From: [REDACTED]
To: [Willows , Helen \(PLANNING OFFICER\)](#)
Cc: [REDACTED]
Subject: Re: 2025/1065 - West Green Recycling Revised Application
Date: 10 March 2026 20:15:28
Attachments: [g64.png](#)
[image002.png](#)
[image001.png](#)

From: Susan Crowley <[REDACTED]>
Sent: 06 March 2026 17:52
To: Willows , Helen (PLANNING OFFICER)
<HelenWillows@barnsley.gov.uk>
Cc: Anthony Lidster <[REDACTED]>
Subject: 2025/1065 - West Green Recycling Revised Application

Figure 11. Proposed Development and elevations of the Filter Press

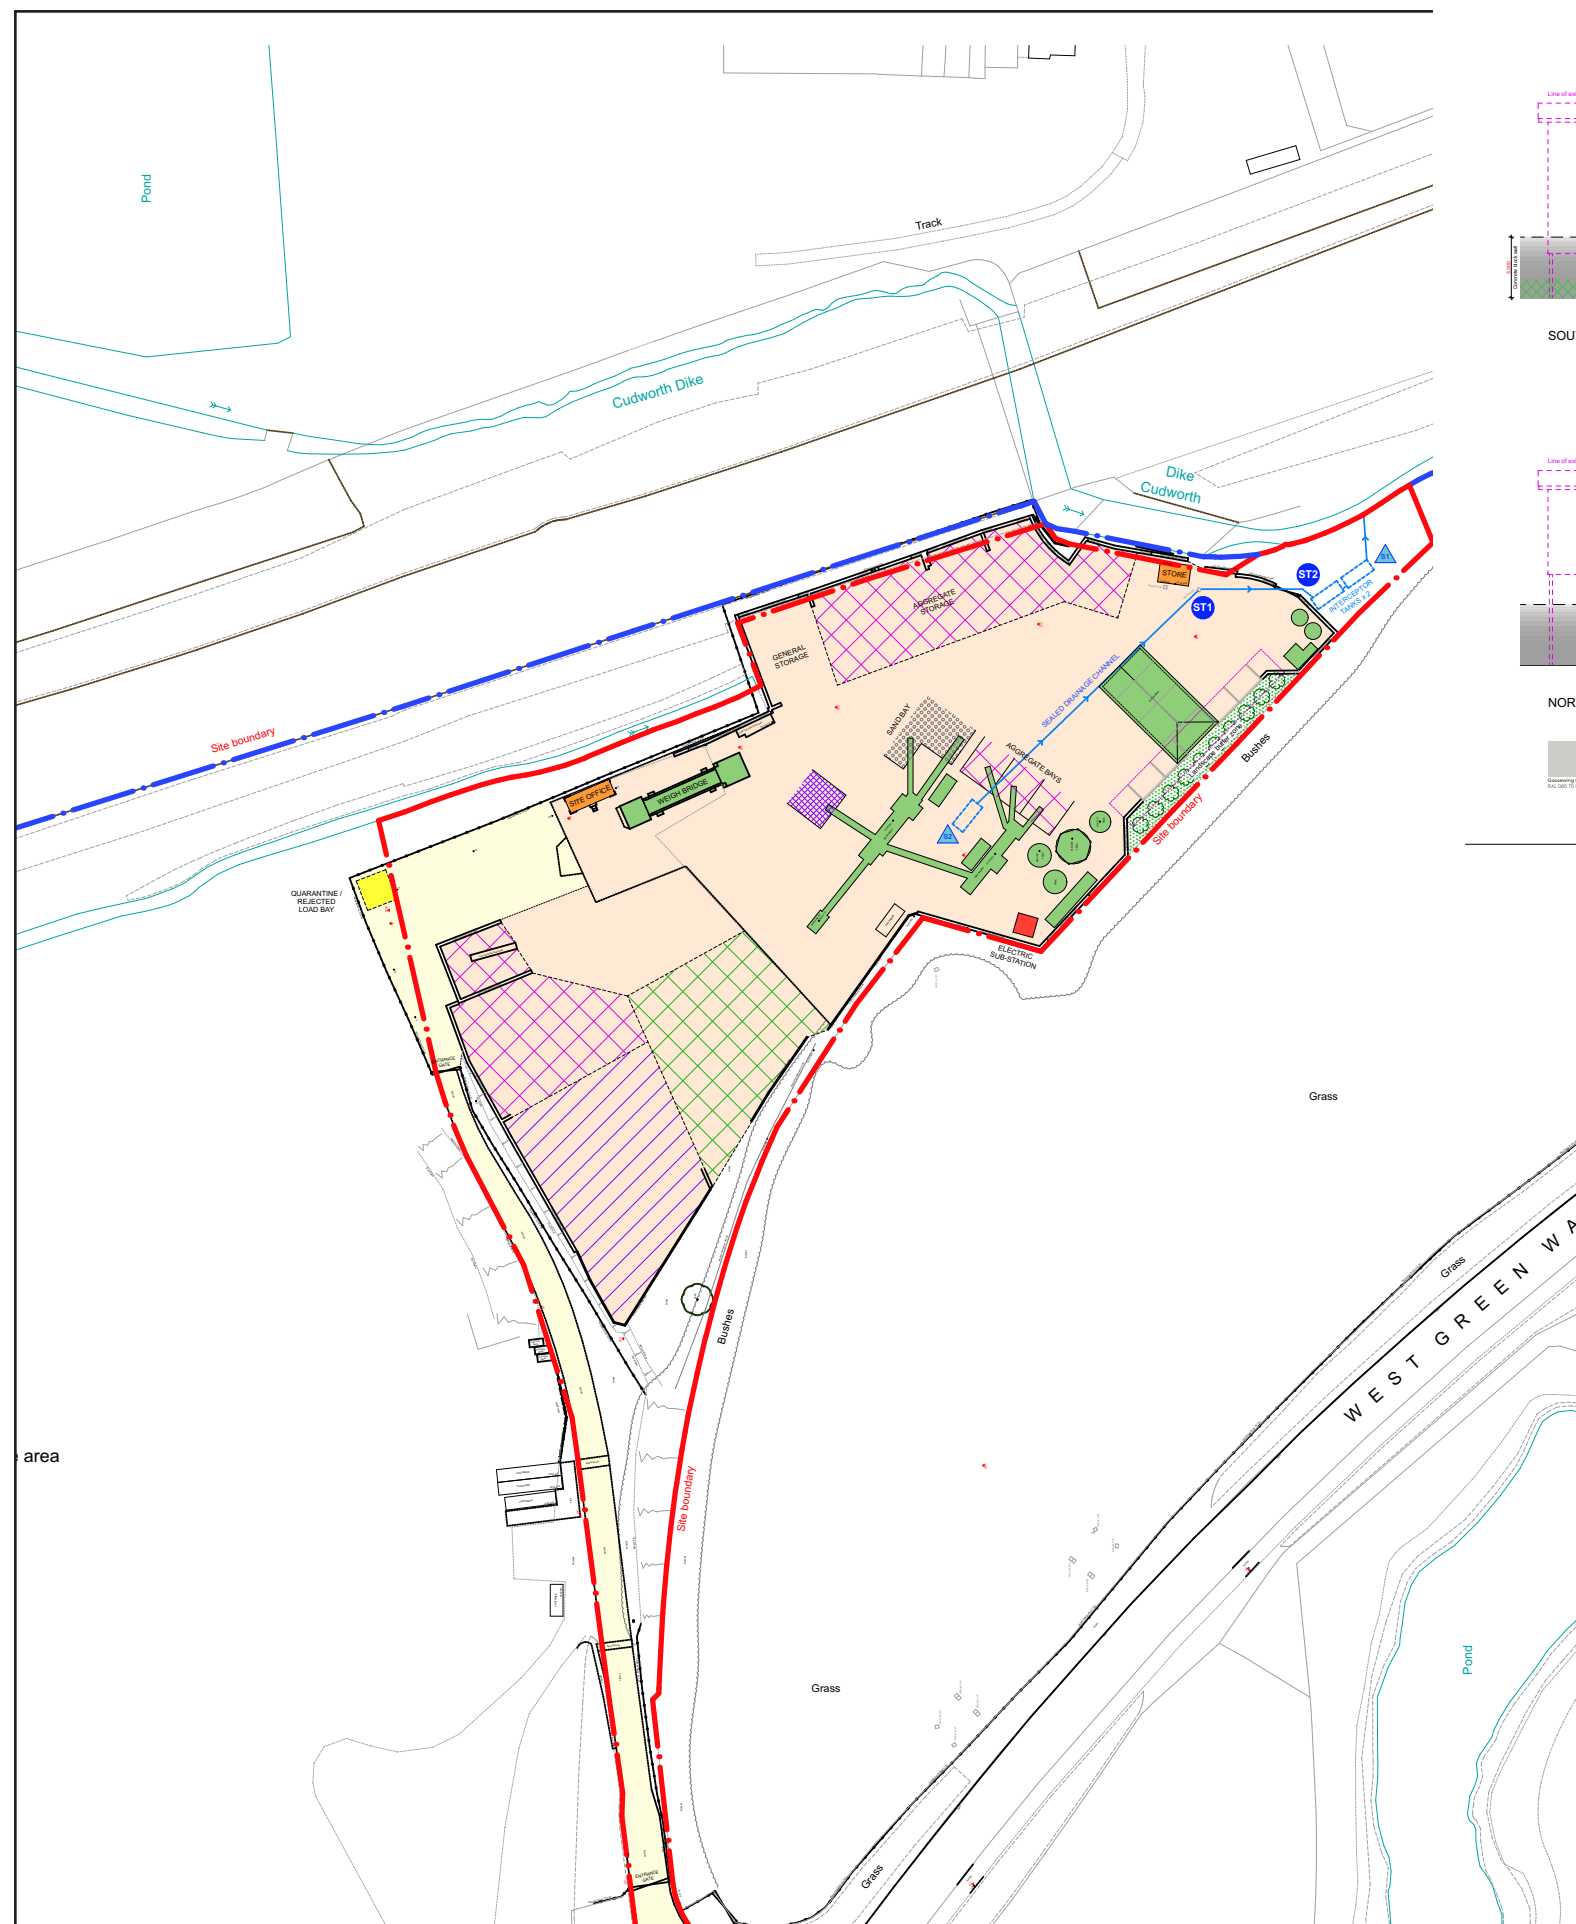
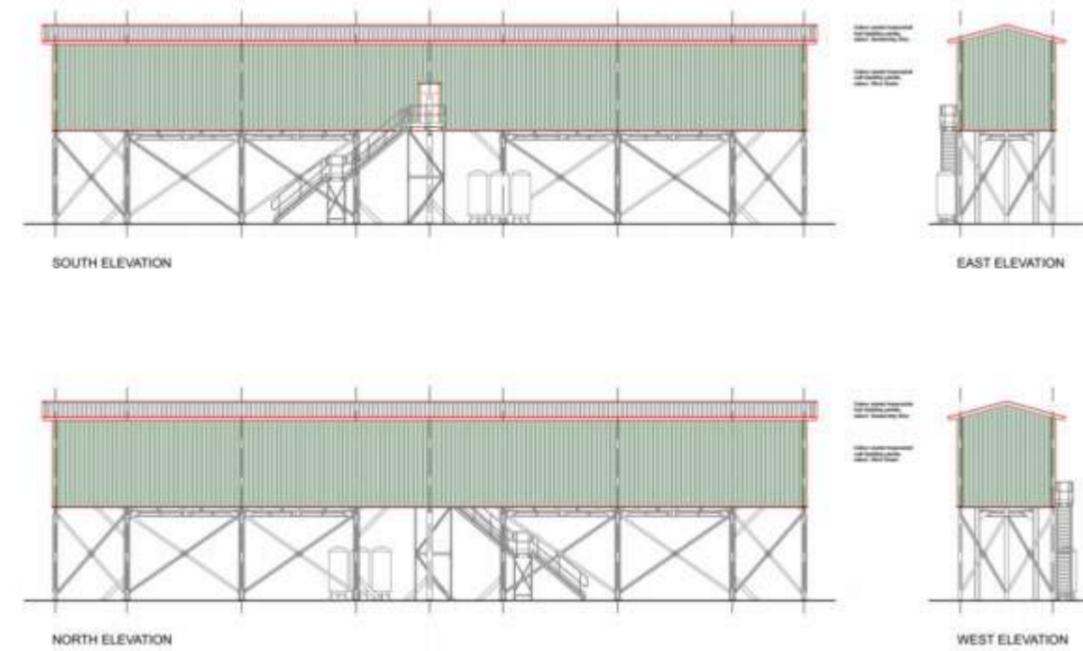
The planting plan does not seem to me to be substantial in scale to fully mitigate the general visual effect of the proposed development in wider views. Neither the planting plan nor the LVIA address the impact of the wider proposed development. The planting plan lacks details of a fully detailed landscaping scheme which would include details of the subsoil and topsoil depths to be secured.

- 1.
2. Thank you for the proposed planting plan. I note that you have not submitted a revised LVIA as I requested nor addressed the impact of the wider proposed development.

- 2.
3. Thank you for your comments about the reduction in the

height of the filter press.

The response does not fully address my request for additional information. Unless I hear from you otherwise, I shall proceed to determine the application in its current form.

The Inspector arrived at his decision in terms of the visual impact of the appeal proposal having regard to the *built form and scale of the filter press* (emphasised in paragraphs 10, 11, 12, 13, 14, and 16 of the decision). More specifically the Inspector was concerned at the prominence of the built form and scale of the filter press in wider views (paragraphs 10 and 14 of the decision refers).

When comparing the visual impact of the filter press to a neighbouring industrial development, the Inspector weighed in the balance how much of the neighbouring building was visible from West Green Way alongside the fact that said industrial building was *flanked by vegetation ... similar in height to it* (paragraph 14 of the decision).

As evidenced within the LVIA, the general visual effect of the proposed development is fully mitigated in wider views. In this regard and in views from West Green Way, the filter press is 'smaller and has less visual mass' and it is set to be 'flanked by vegetation which it is similar in height to it. The proposed planting is modelled in all viewpoints contained within the LVIA at year 1 and year 15.

3. The change in height to the filter press housing has been made possible simply by building in efficiencies to the internal access and circulation arrangements - nothing more.
